3A07/1008-05 (D12/23943)

7 February 2012

**Shoalhaven Starches Bomaderry
Modification Application (MP 06_0228 MOD 2)**

OVERALL SITE PLAN SHOWING ETHANOL MODIFICATIONS
FOR SHOALHAVEN STARCHES P/L NOV 2011

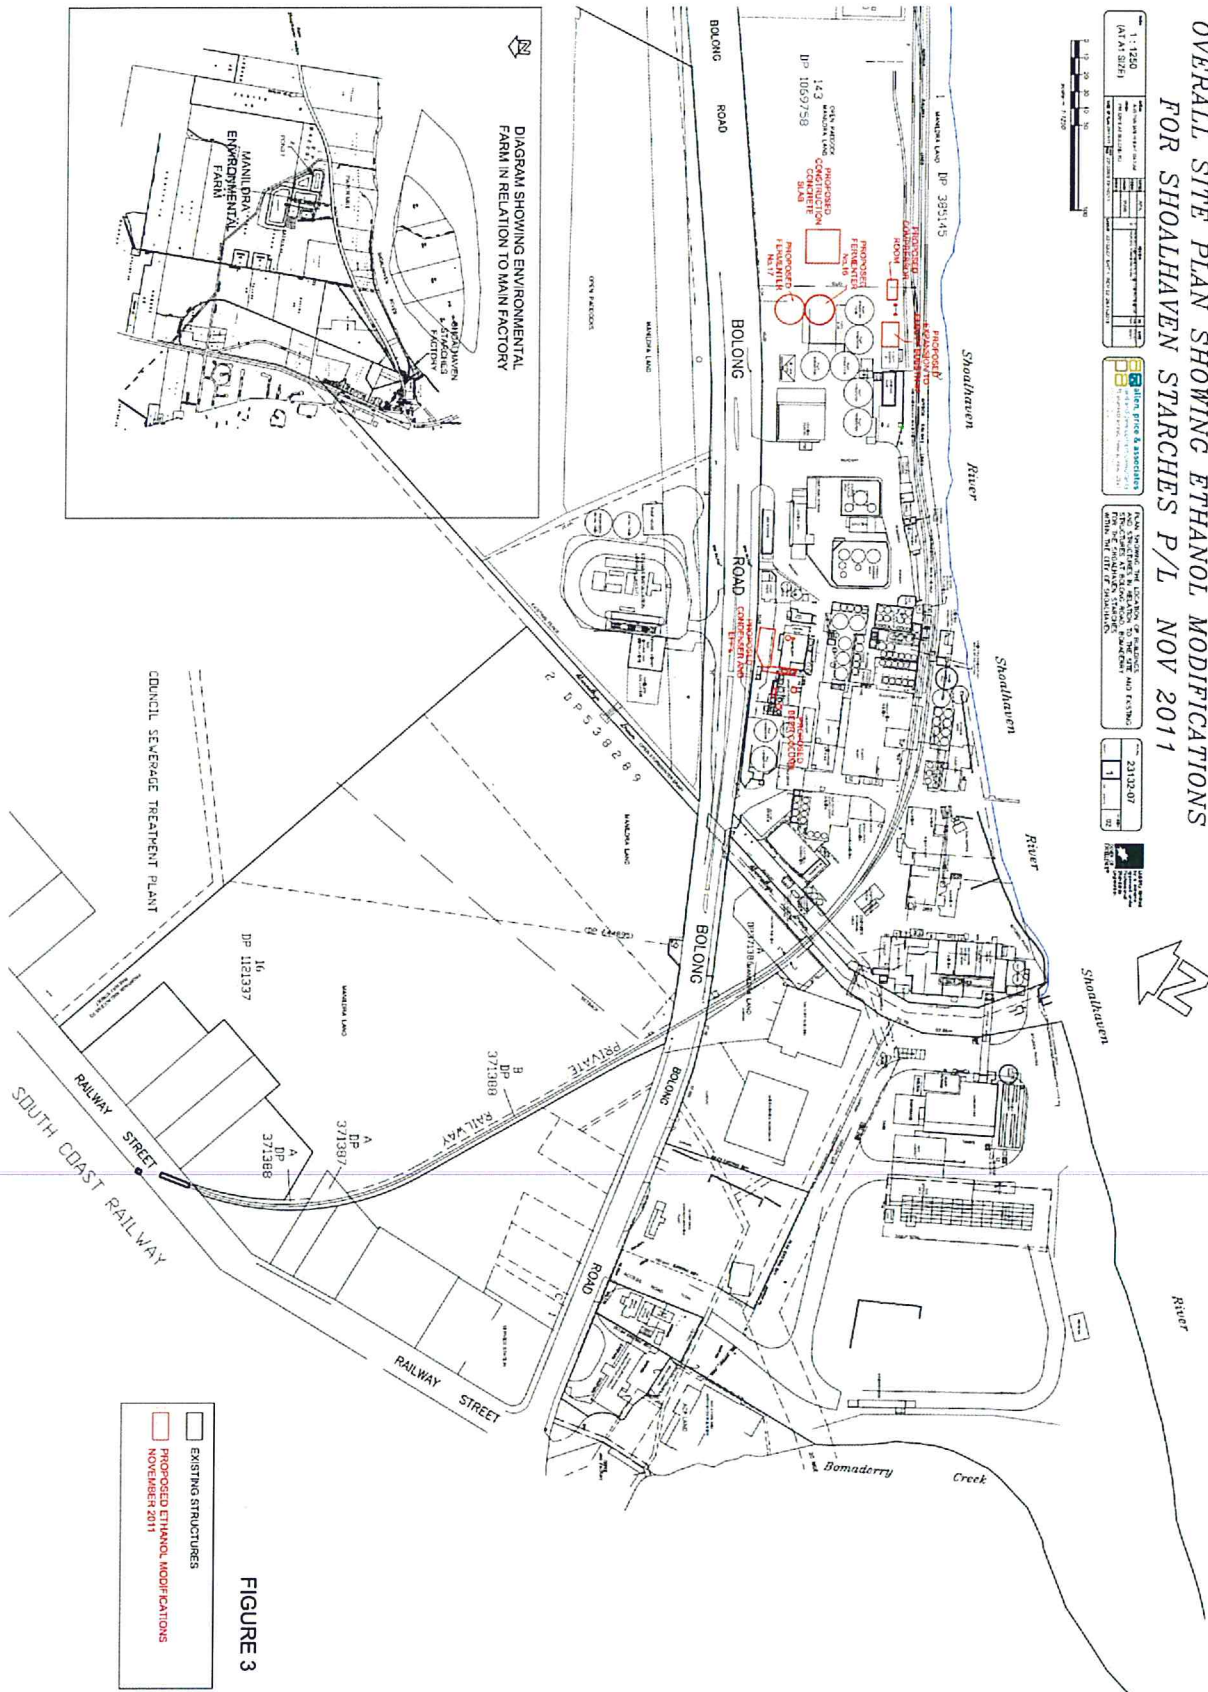
The location for the proposed condenser structures are on a minimal setback to Bolong Road and this will preclude the use of the existing grassed area for appropriate screen planting. Council requests the Department to consider an alternate location for the structures and to review the compliance issues with Condition 43.
